**Consultation Response from KC,
Highways Development Management**

2023/90988 rear of, 3, East Fold, Skelmanthorpe, Huddersfield, HD8 9EZ

Erection of detached dwelling

Date Responded: 1-8-2023.

Existing Block Plan

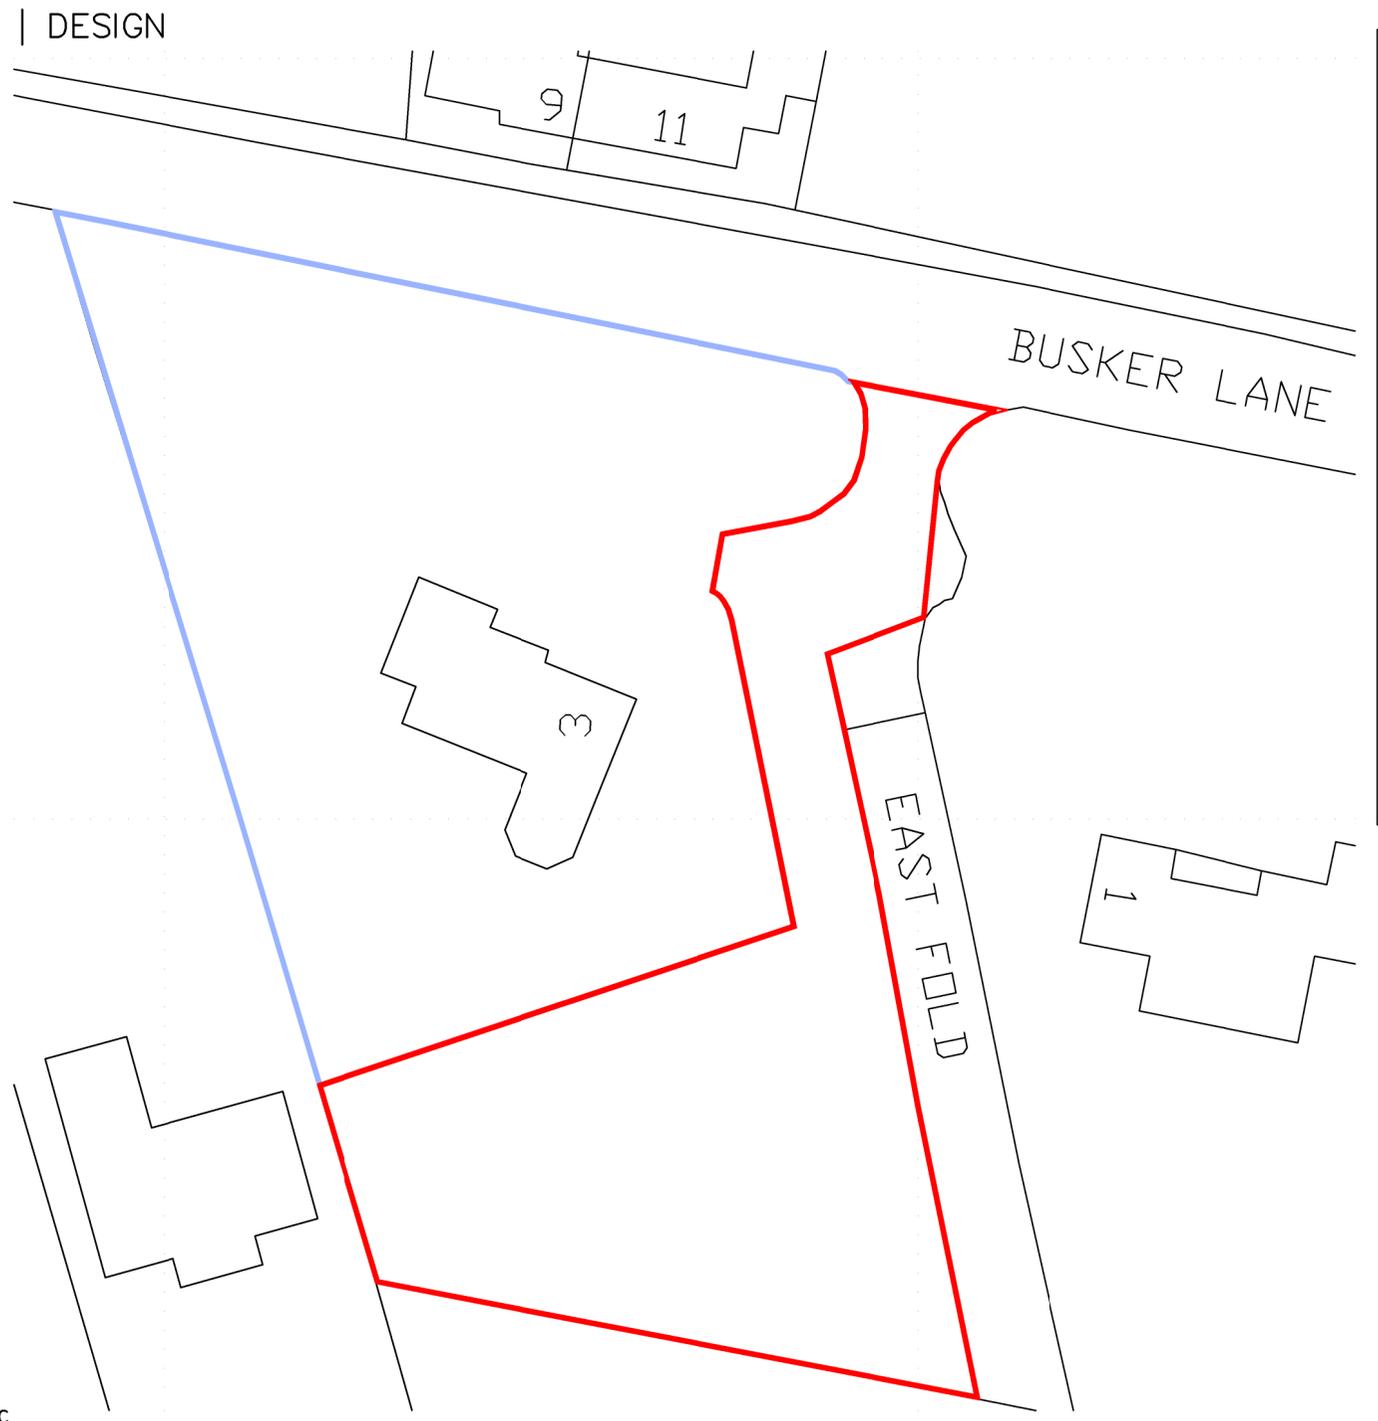
A small turning area is shown on the plans at the head of the proposed private driveway.

1, Two independent off-street parking spaces with internal turning should be shown on the plans. The proposed driveway as shown is not wide enough to allow two vehicles to pass, scaling 3.5m in width, and will not therefore allow a vehicle to use the turning space and exit the site past a parked vehicle. Given that Busker Lane is a classified road internal vehicle turning should be provided that allow two vehicles to enter, park and exit in a forward gear.

2, The existing access into the site as a narrow footway and driveway. Can the applicants confirm the width of the existing driveway which should be a minimum of 4.5m to allow vehicles to potentially a pass at the access.

3, Sight lines from the exiting access onto Busker Lane to the east or left when exiting the site are poor. Can the applicants confirm their proposals to improve the proposed sight lines onto Busker Lane.

In this case the proposed dwelling is over 45m from Busker Lane and the driveway is over 20m in length.

5, Bin collection points should be provided to both dwellings to enable bins to be presented on collection day without either obstructing the highway or proposed driveways.
